**KIRKLEES METROPOLITAN COUNCIL
INVESTMENT & REGENERATION SERVICE**

Reference No: 2021/62/90890/E

Site Address: Wilman And Son, 1, Market Place, Batley, WF17 5DA

Description: Alterations to convert estate agent to restaurant/cafe
(Class E) (Listed Building within a Conservation Area)

PROJECT:	DESCRIPTION:	TITLE:	DRAWING REF:	REV:
1 MARKET PLACE, BATLEY, WF17 5DA	CHANGE OF USE FROM A2 TO A5	SITE PLAN DRWN BY: HED	20163-D02-B	
		DATE: 14/04/21

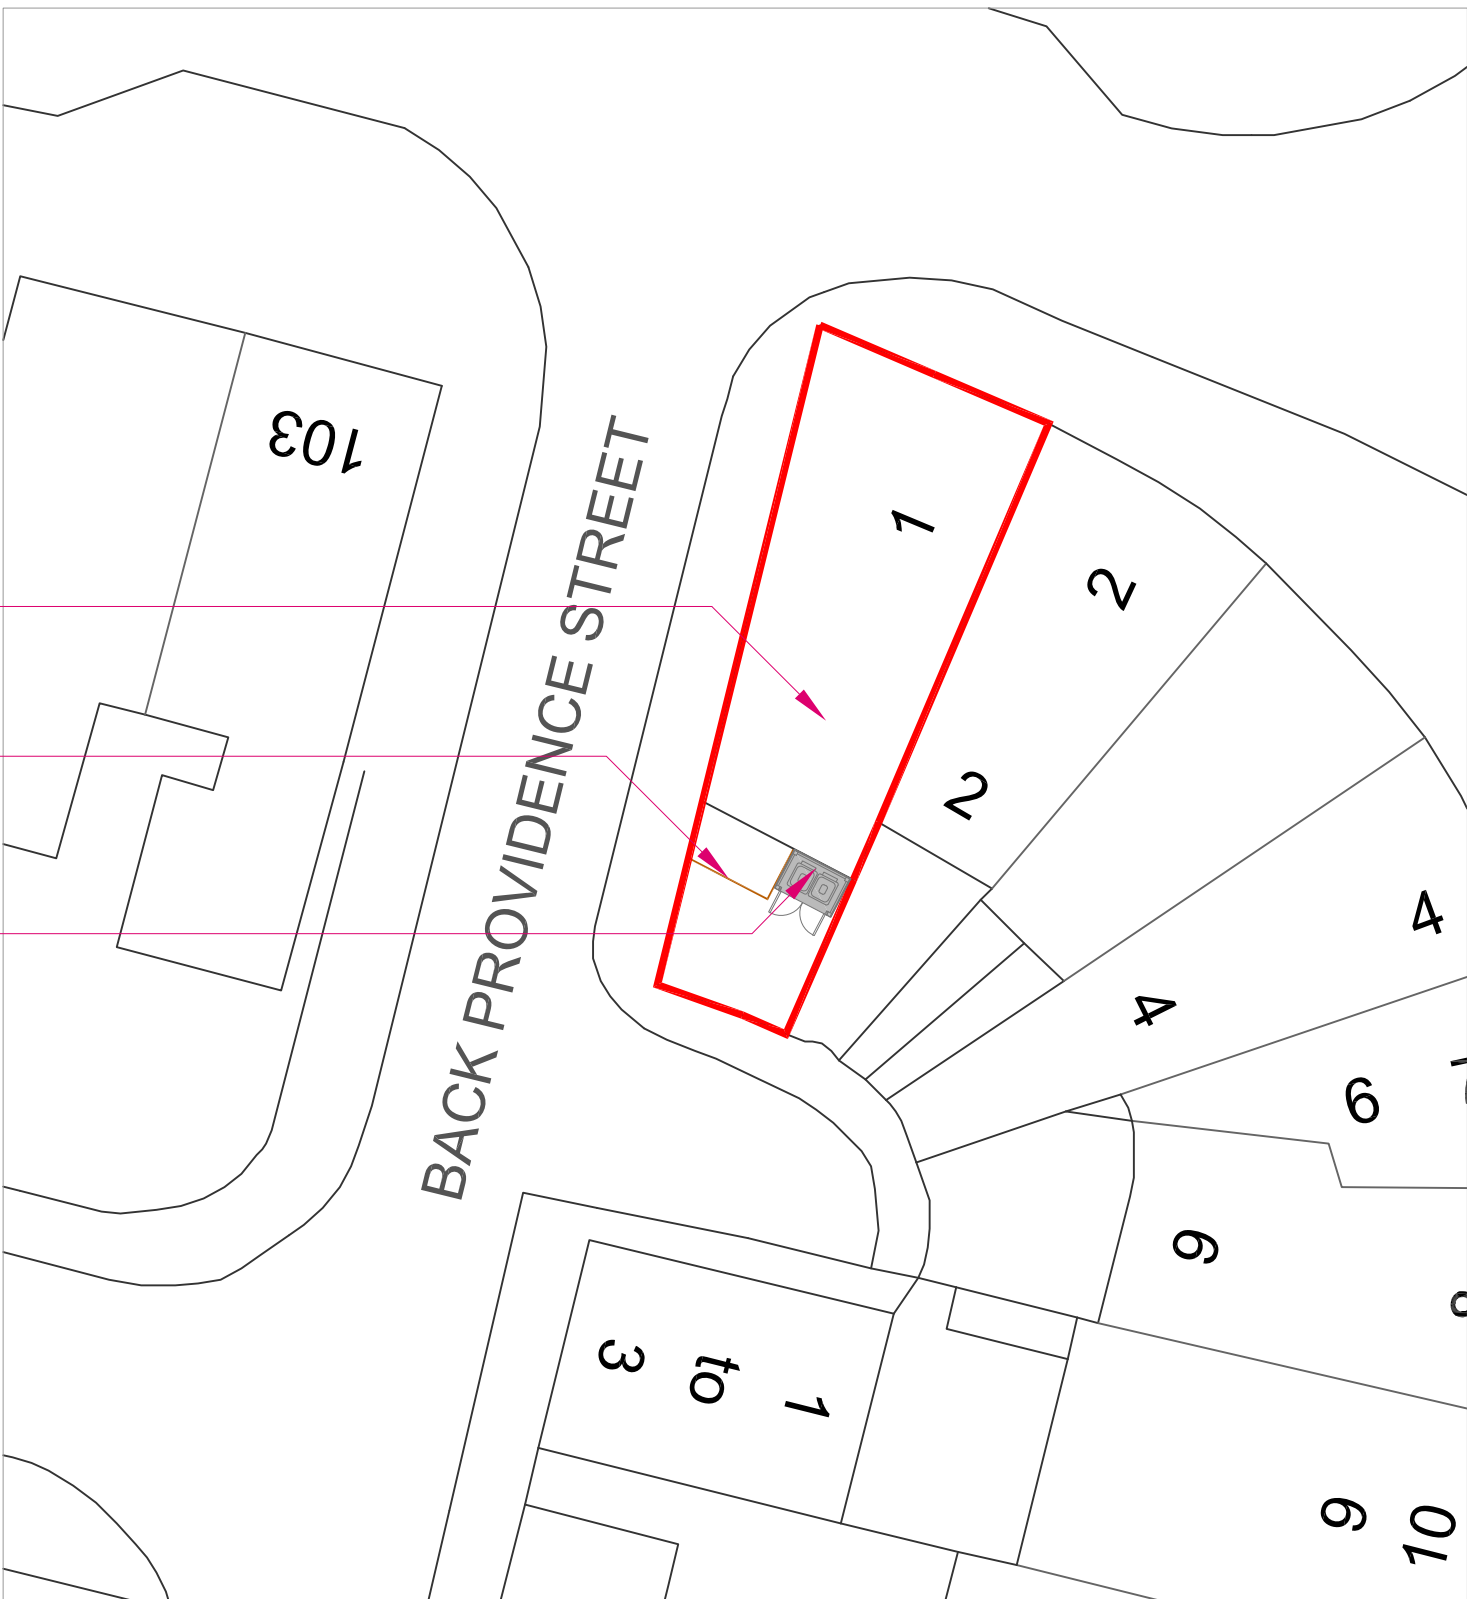
The application proposes alterations to the interior and exterior of the building. The proposed works include stripping out finishes; the repair of the existing timber shop front; the replacement of the existing ground floor window with a smaller timber sash window; the insertion of a new rear door; the installation of a black flue from above the ground floor window to above eaves level; erection of a 1.8m high black metal railing; and a bin store is proposed in the rear yard area.
